Rustington Parish Council

Our Ref: CW/CH/JM/PLAN/21
Date: 3 December 2021

R/108/21/PL - Demolition of two dwellings and the construction of 3 No. 3-bed town houses and 5 flats. This site is in CIL Zone 4 and is CIL Liable as new dwellings - 117 Sea Lane, Rustington

A REV	27/10/21 DATE	Second floor removed. DESCRIPTION	18th Mar 2021		EL	
			DRAWING TITLE PROPOSED STREET ELEVATIONS 1			
			SCALE 1 : 100@ A1		DRAWING NO. P202

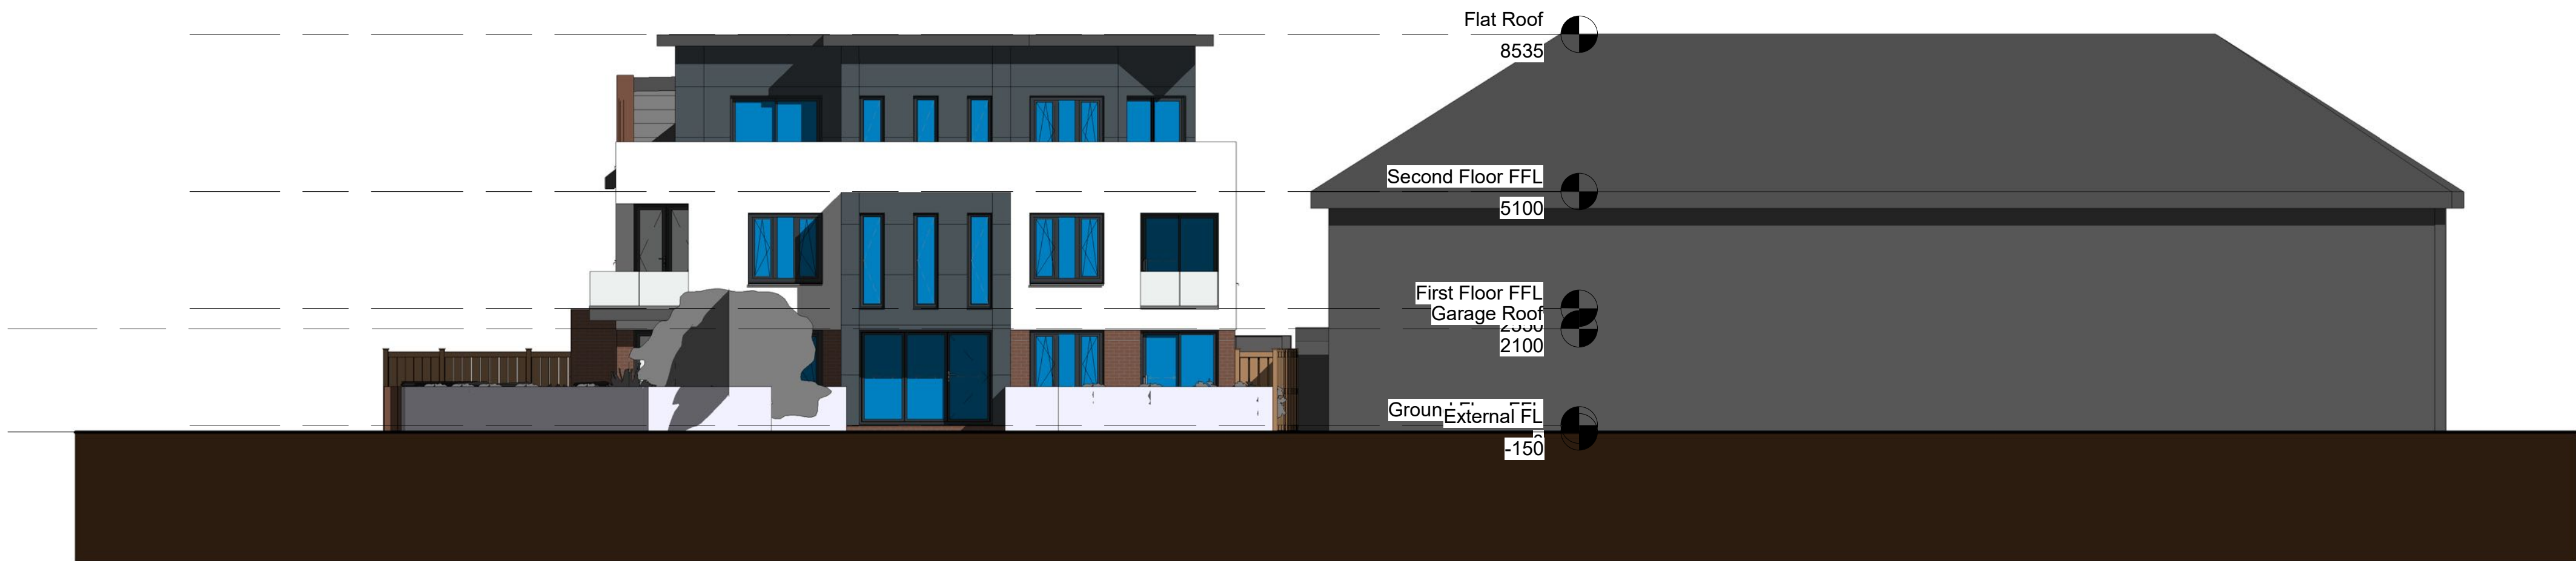
- (i) The proposal to develop this site by the erection of 3 No. 3-bed town houses and 5 flats would still present an extreme over-dominant appearance and would have a damaging impact, by reason of their shape and mass, on the residential amenities of properties in close proximity and the appearance of the street scene (In conflict with Arun District Local Plan Policy DSP1)

- (ii) The proposal, which would be taller than No. 2 Shaftesbury Road, would present an over-bearing and unsympathetic appearance for the occupiers of this property, in particular, which would result in a loss of privacy by reason of overlooking and would, most certainly, adversely affect the quiet enjoyment of the occupiers of the aforementioned property

- (xi) The design of the flats with a flat roof is totally out of keeping architecturally with all of the other properties in the immediate area which have pitched roofs
